WASTE MANAGEMENT FACILITY, BOTANY (SSD-62855708) – GOODMAN SUBMISSION

Goodman has several concerns regarding the Waste Management Facility (SSD-62855708) at 2-4 Hales Street (the Site), which is currently under consideration for the construction and operation of a waste management facility handling up to 300,000 tonnes of construction and demolition waste per annum (the Proposal). Our primary concerns involve the traffic impacts resulting from the Proposal.

Drawing Title
SITE PLAN
 SHEET NUMBER
1220011_A005
 ISSUE
K

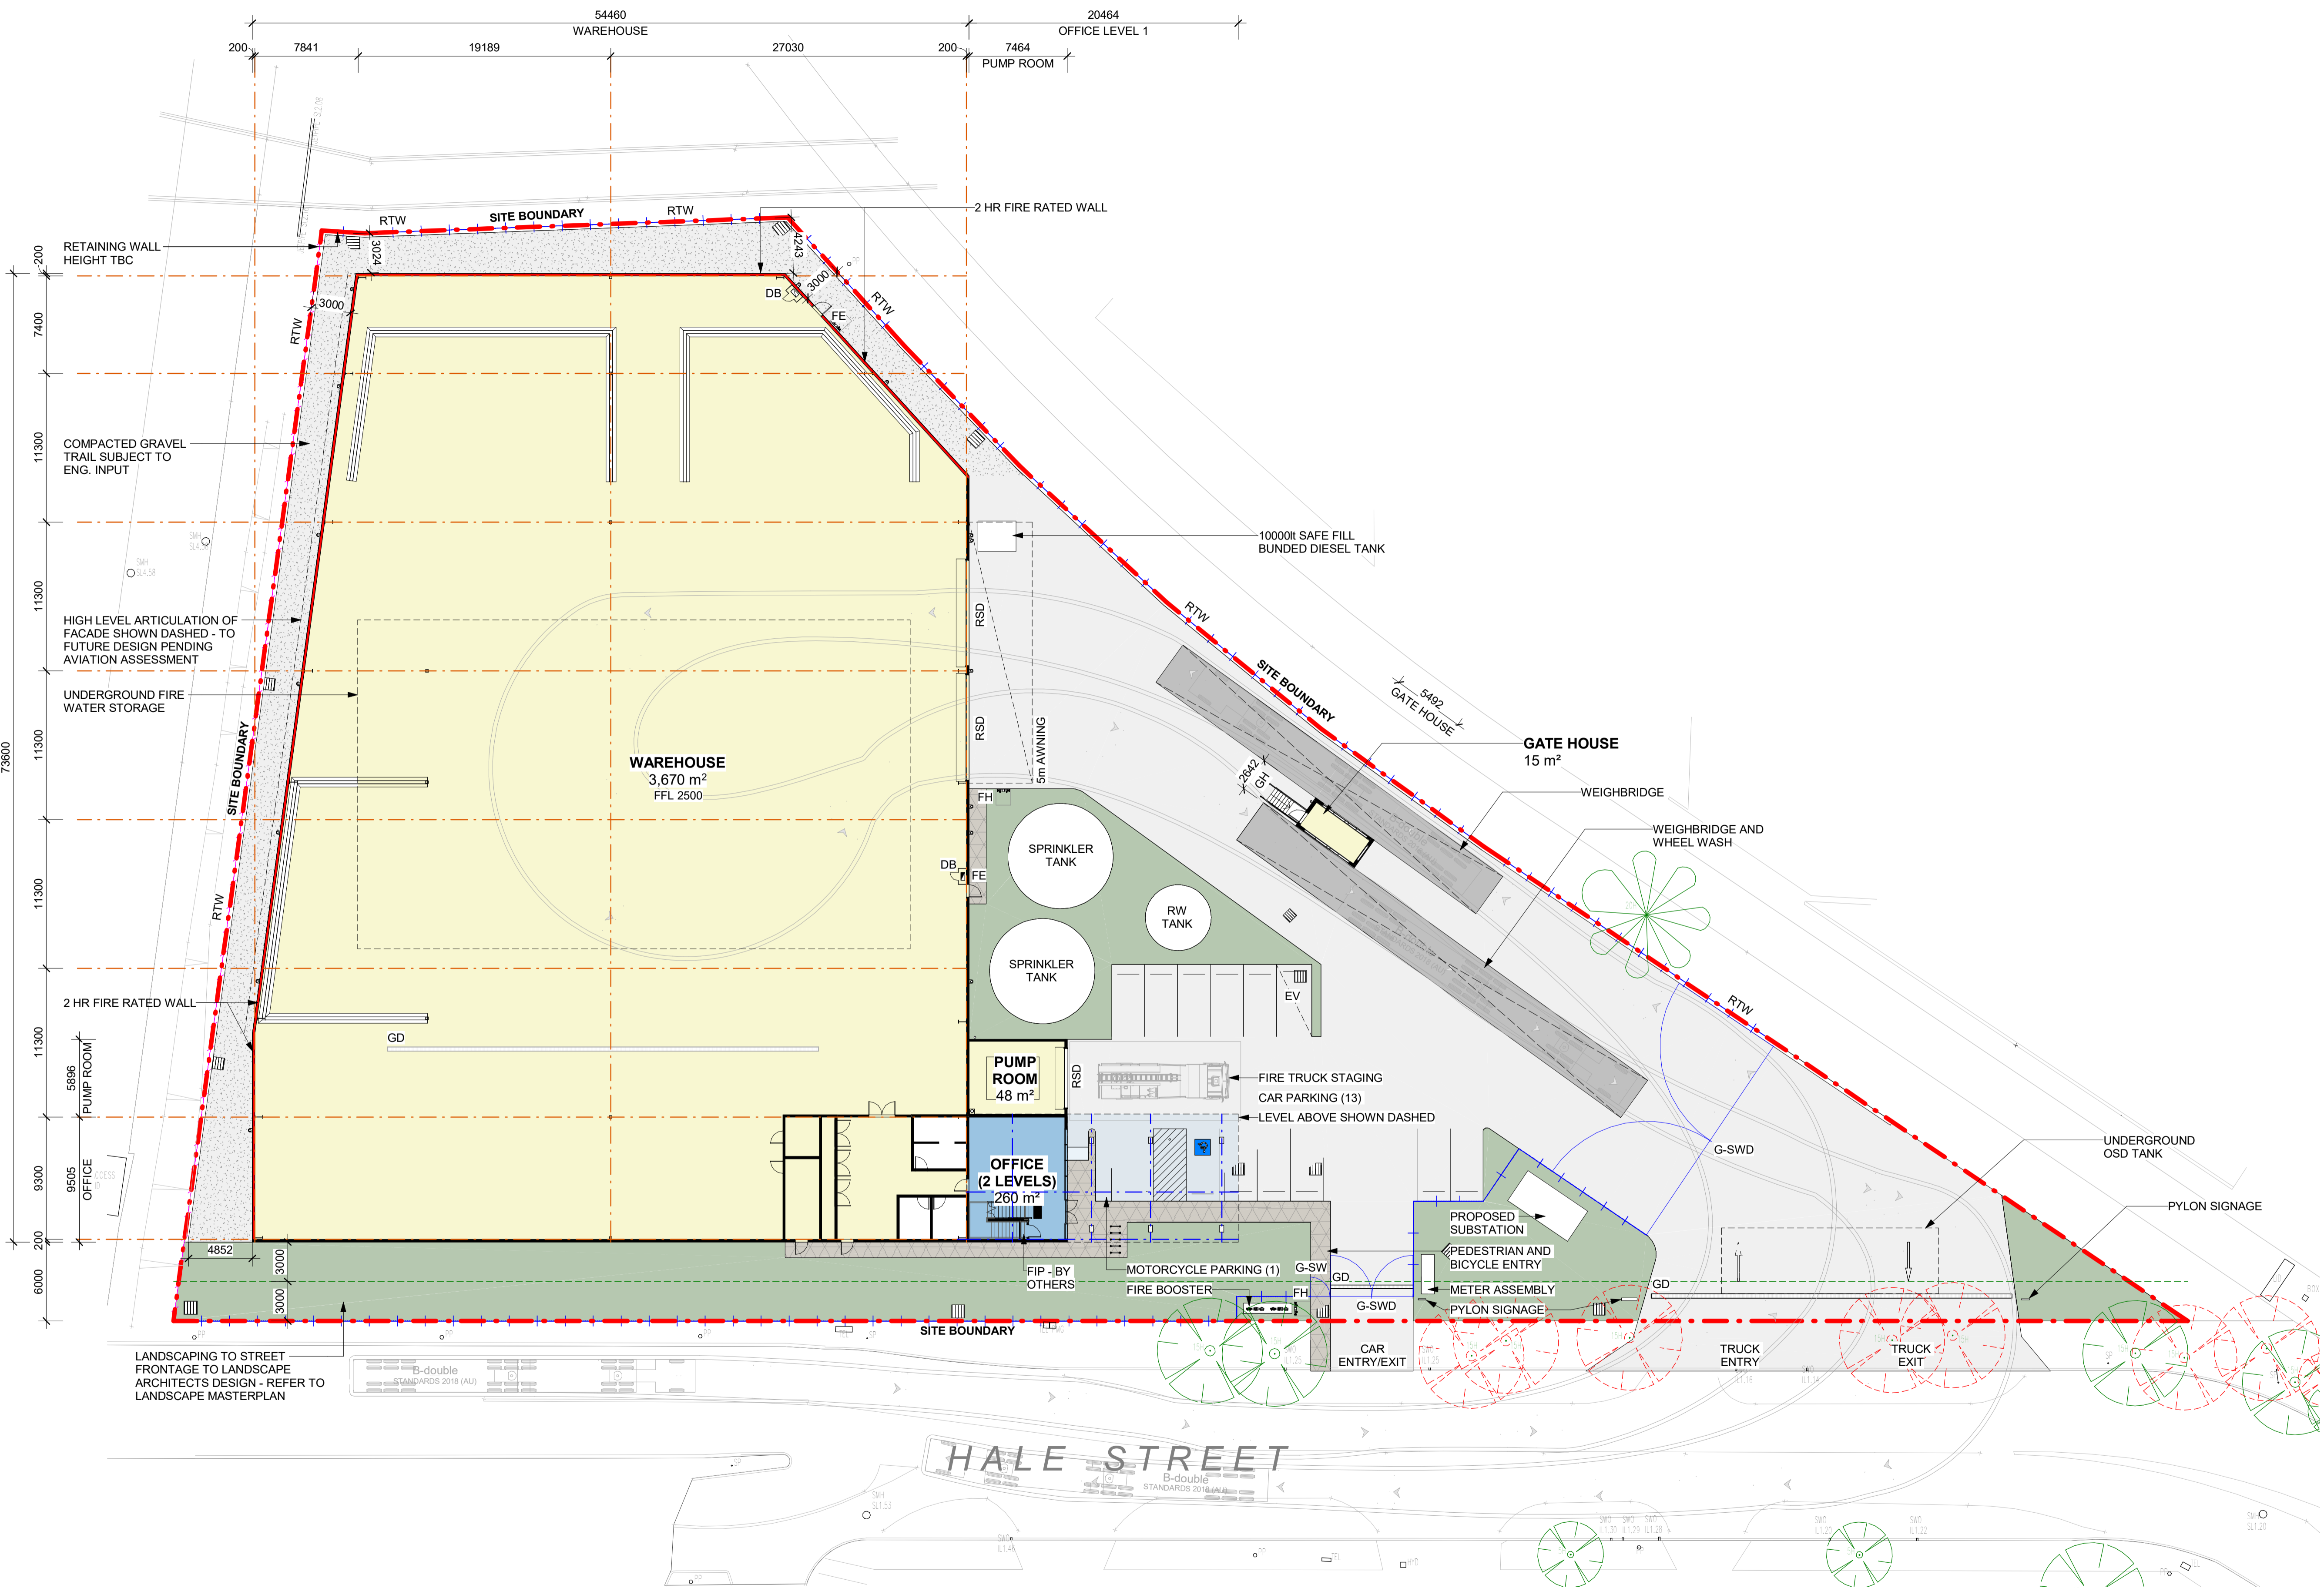
- The Proposal's 29-meter-wide truck access is less than 20 meters from the Hale/Luland Street roundabout. This proximity raises safety issues, highlighting the need to include the roundabout in the assessment.

Project No.	Drawing Phase	Drawing No.	Rev.
23.464	DA	TX.02	A

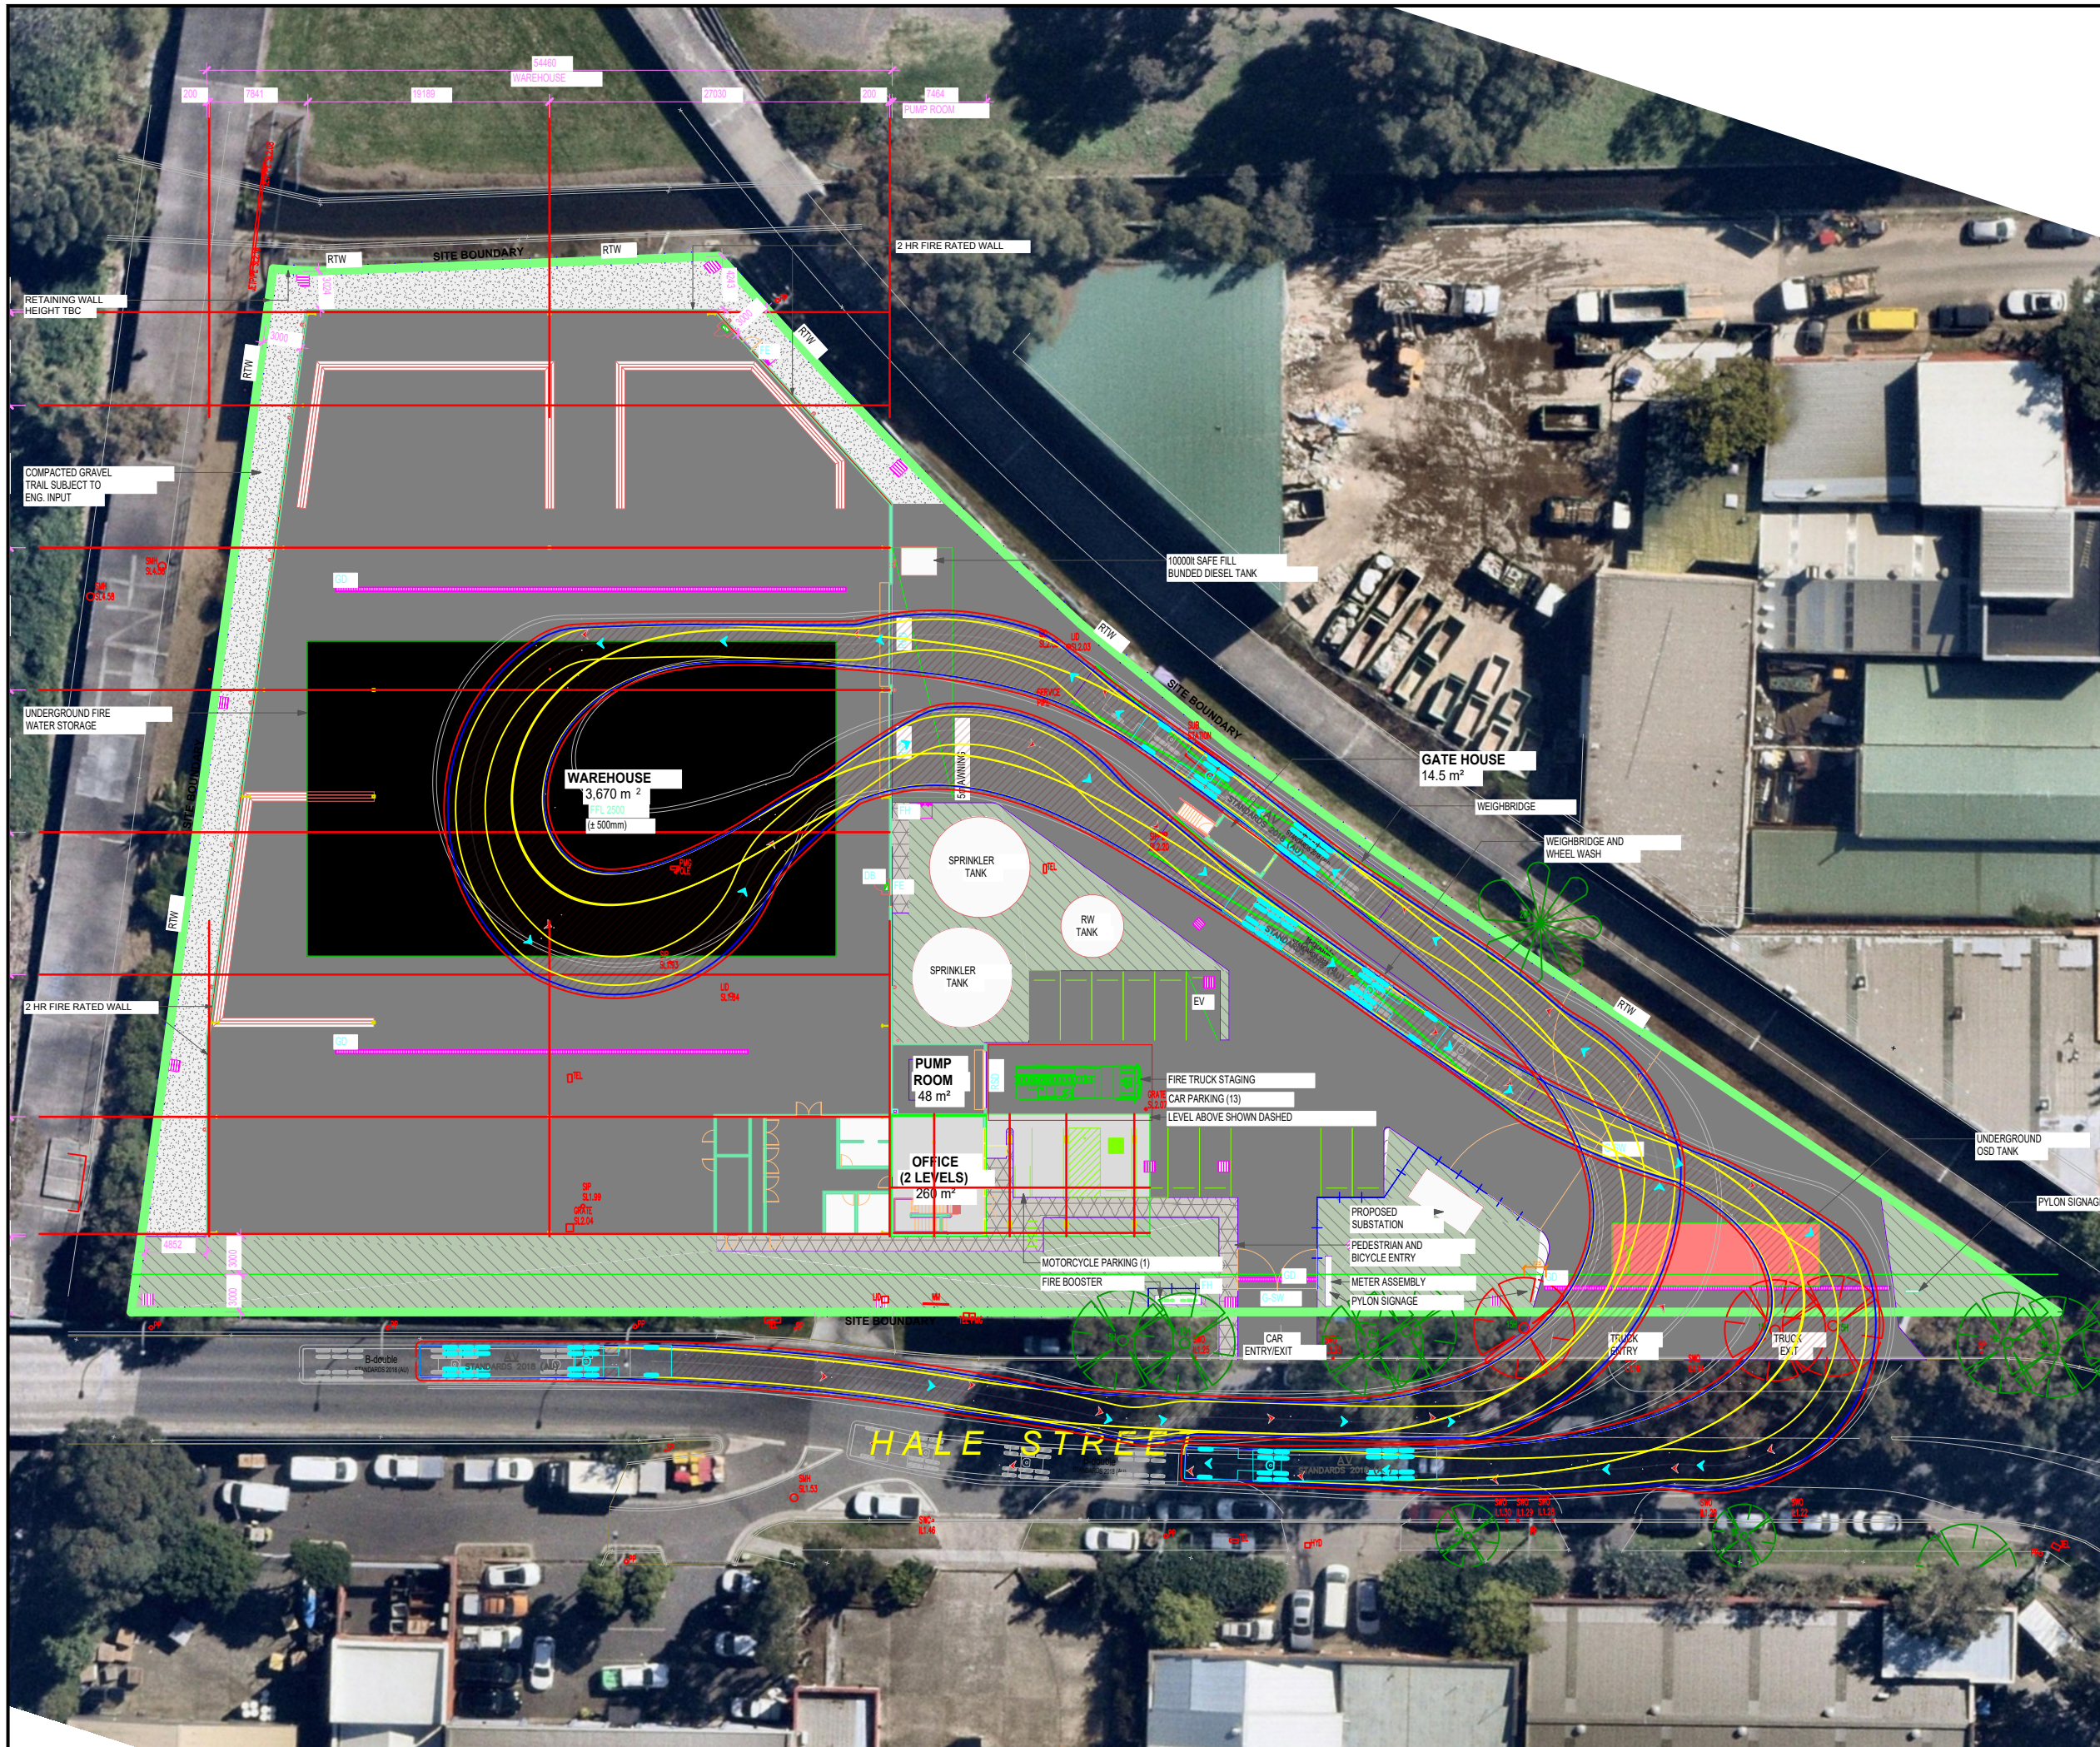
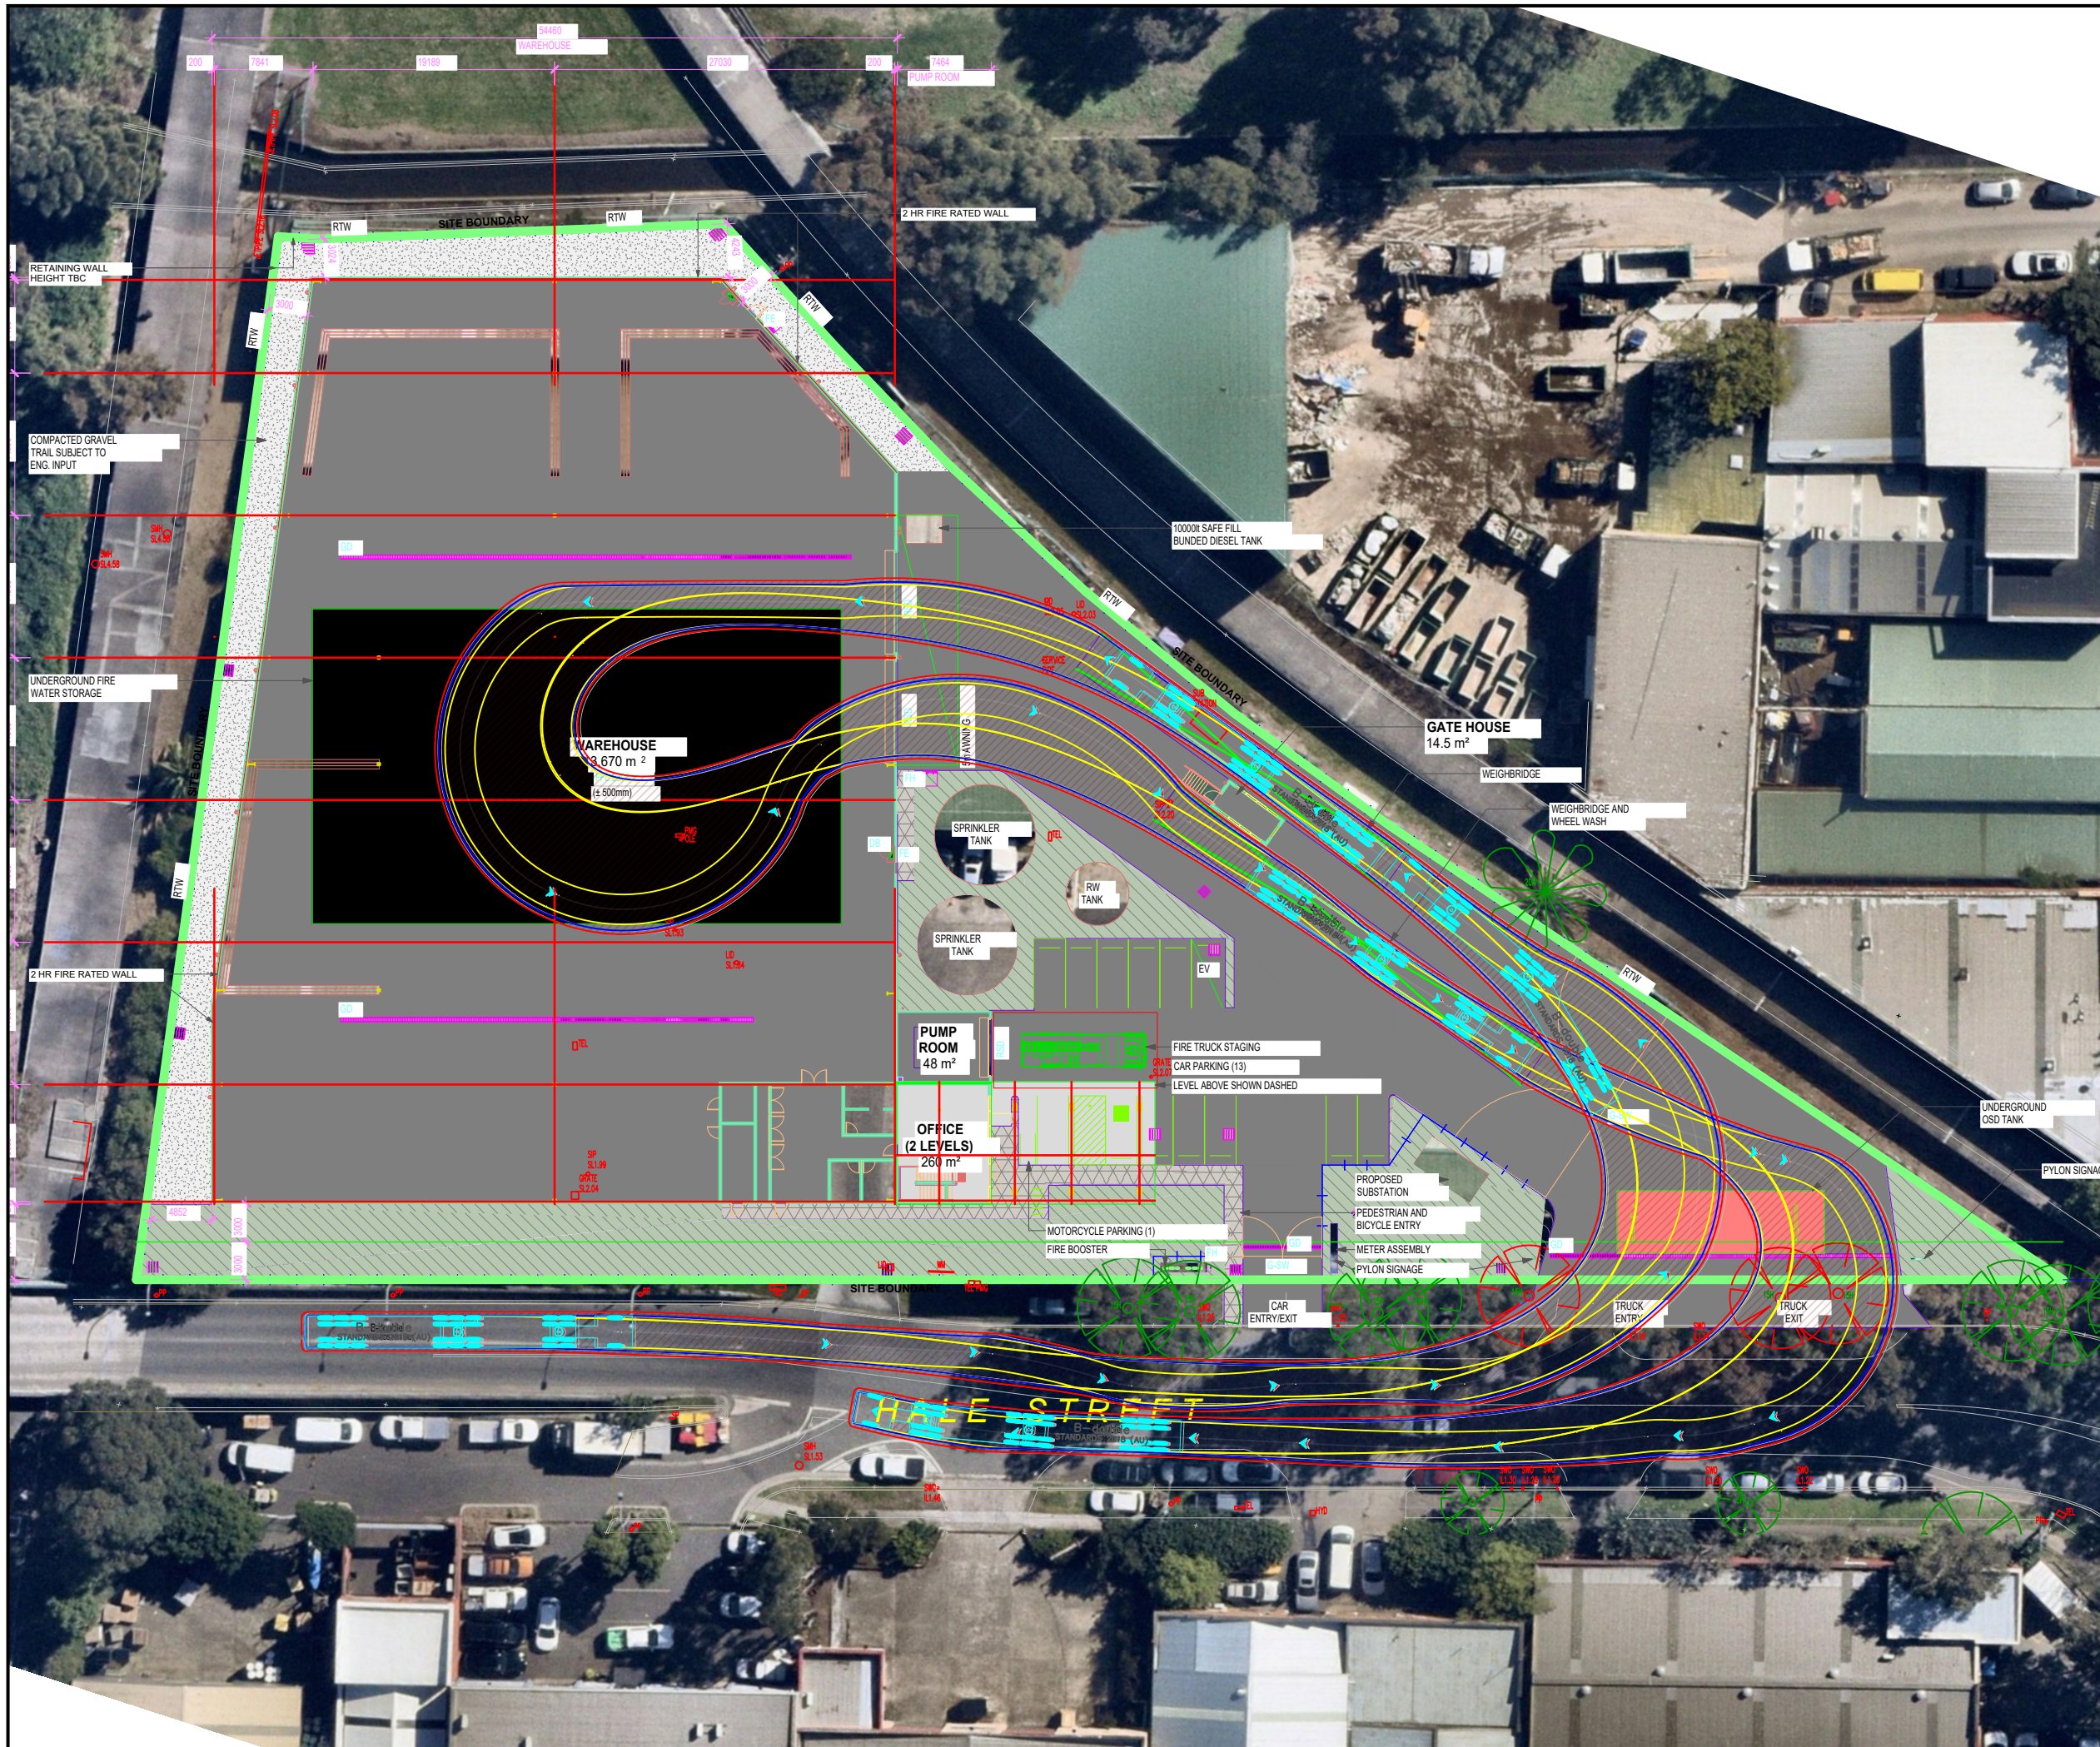
- The swept path analysis shows that exiting B-double vehicles might encroach onto parked vehicles on Hale Street's southern side and cross into opposing lanes when entering, posing potential safety concerns.
